Application for Planning Permission

Development: Retention of change of use of first and second floor office to an 5 bed HMO. This application is in CIL Zone 4 (Zero Rated) as other development.
Location: 51-51a Aldwick Road Bognor Regis PO21 2NJ

TITLE
Block Plan

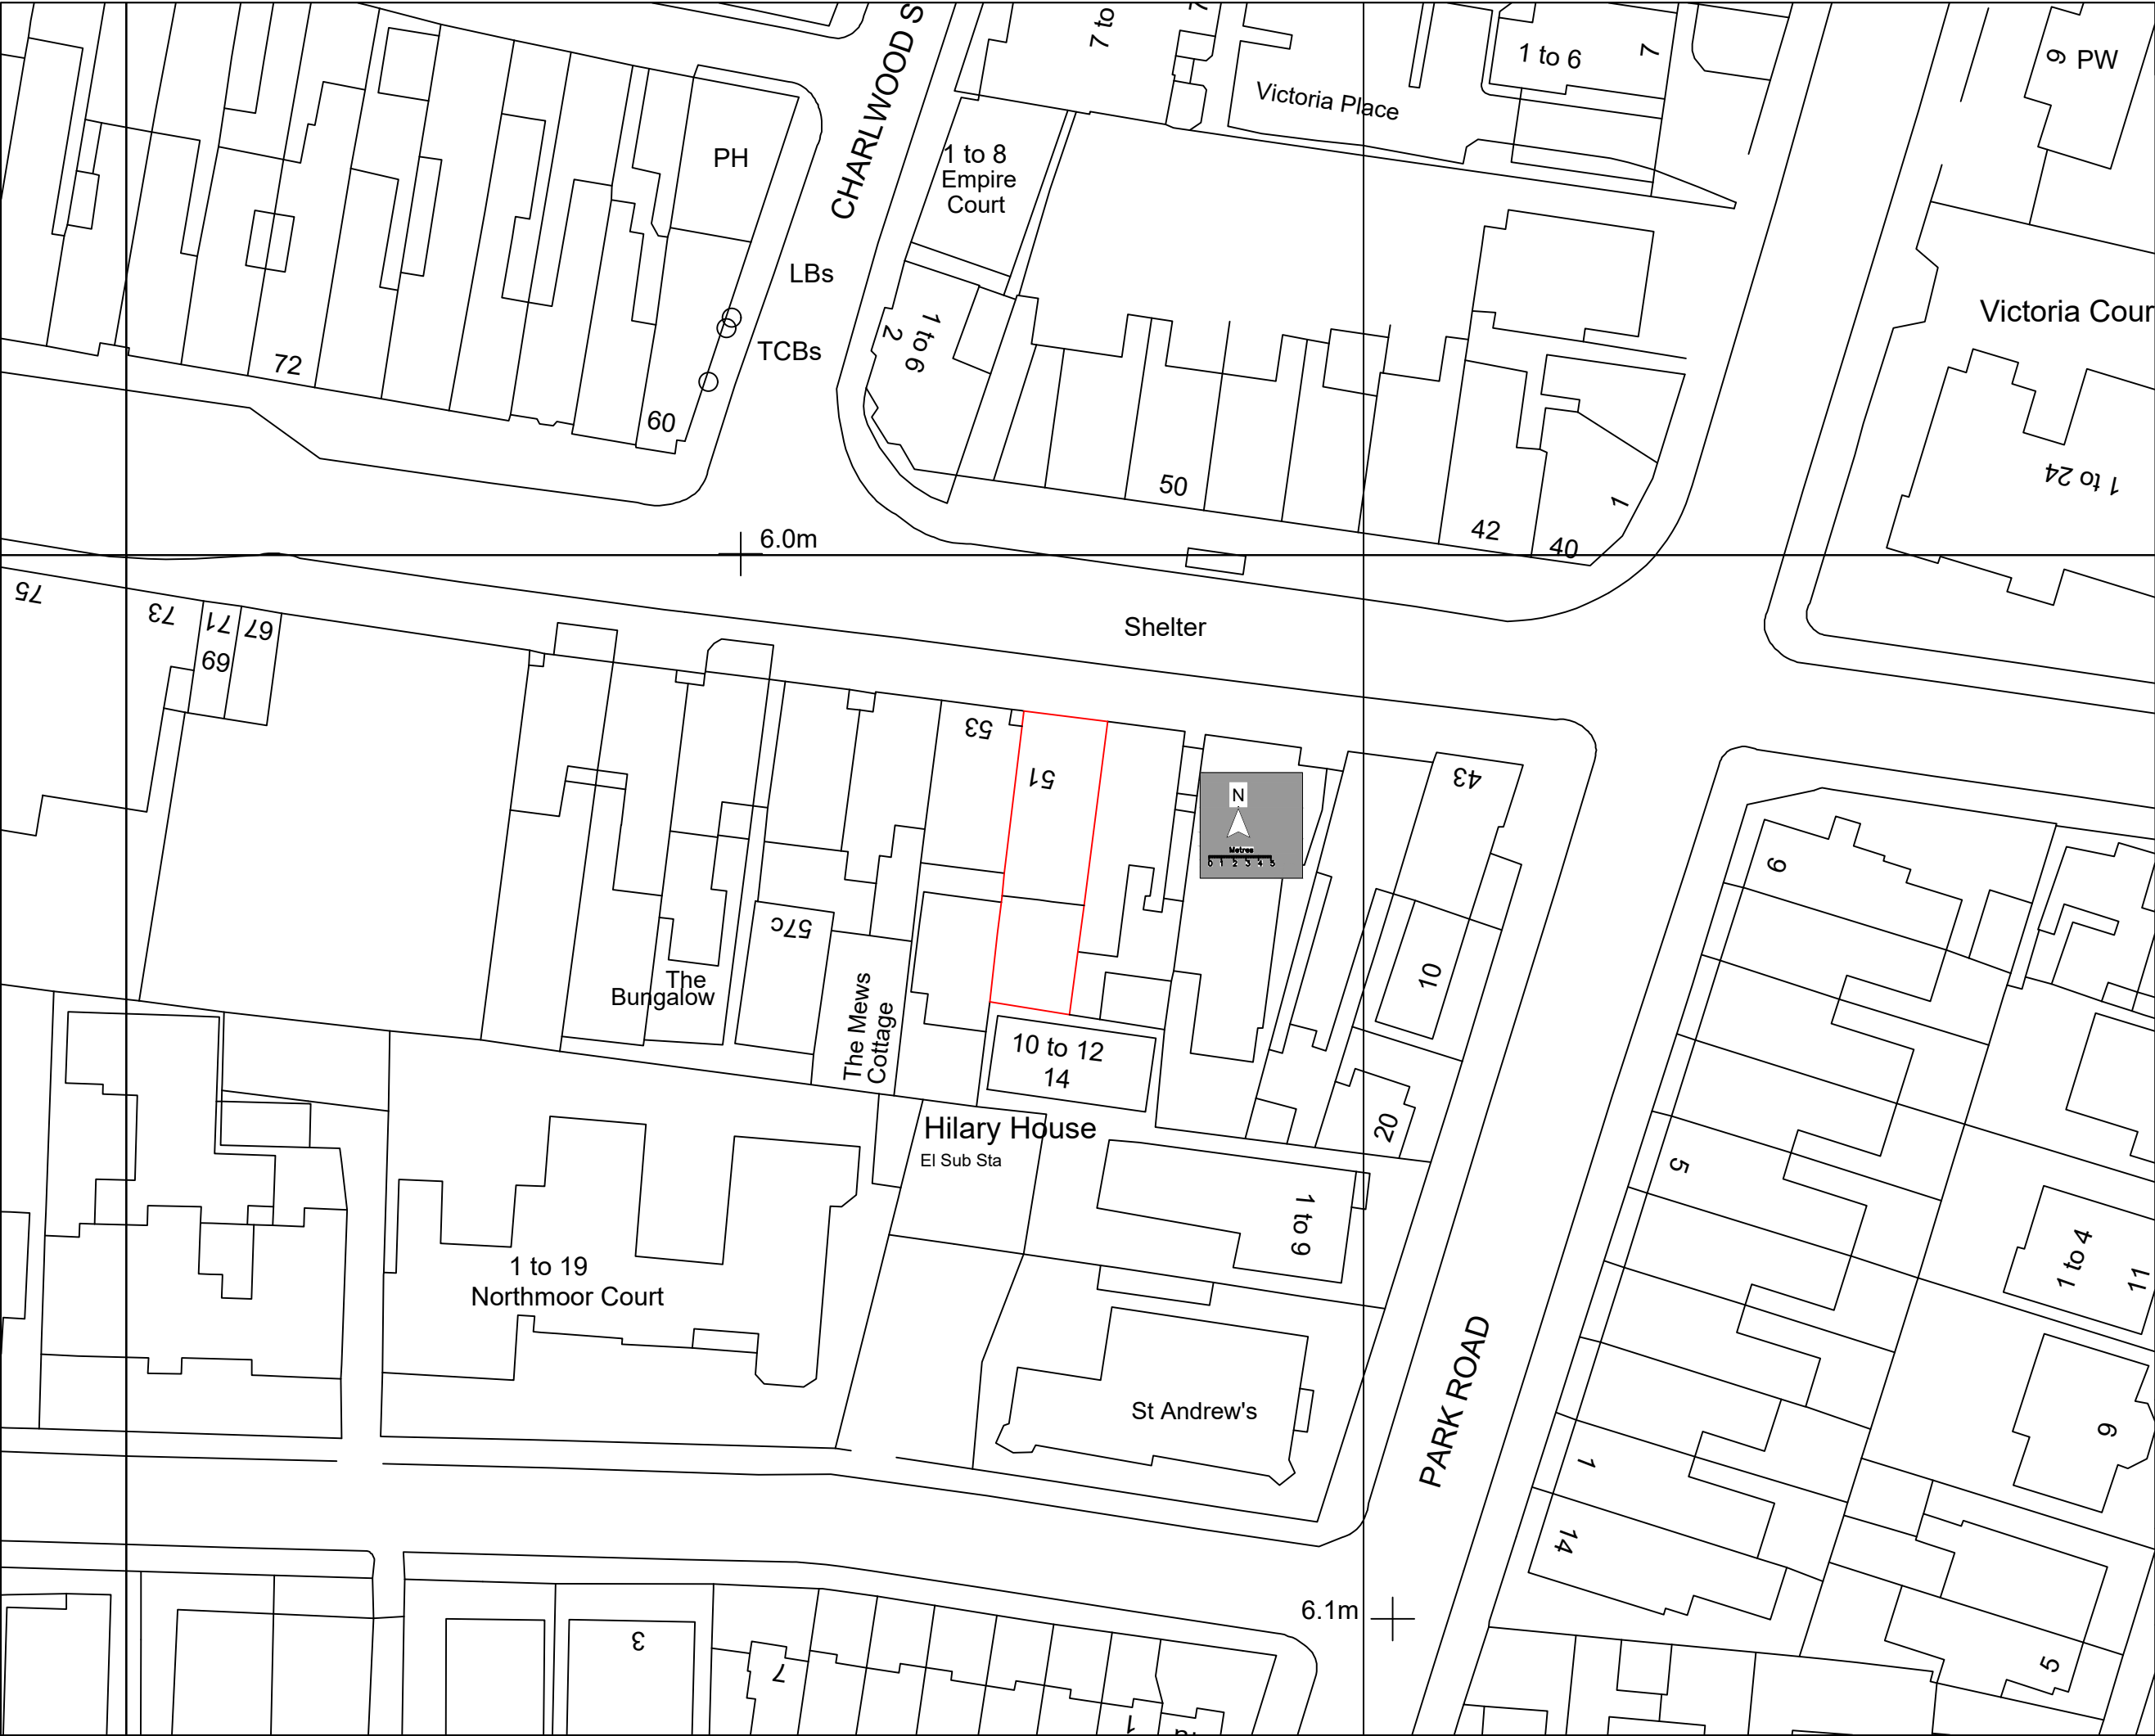
Block Plan

Please provide a north point.
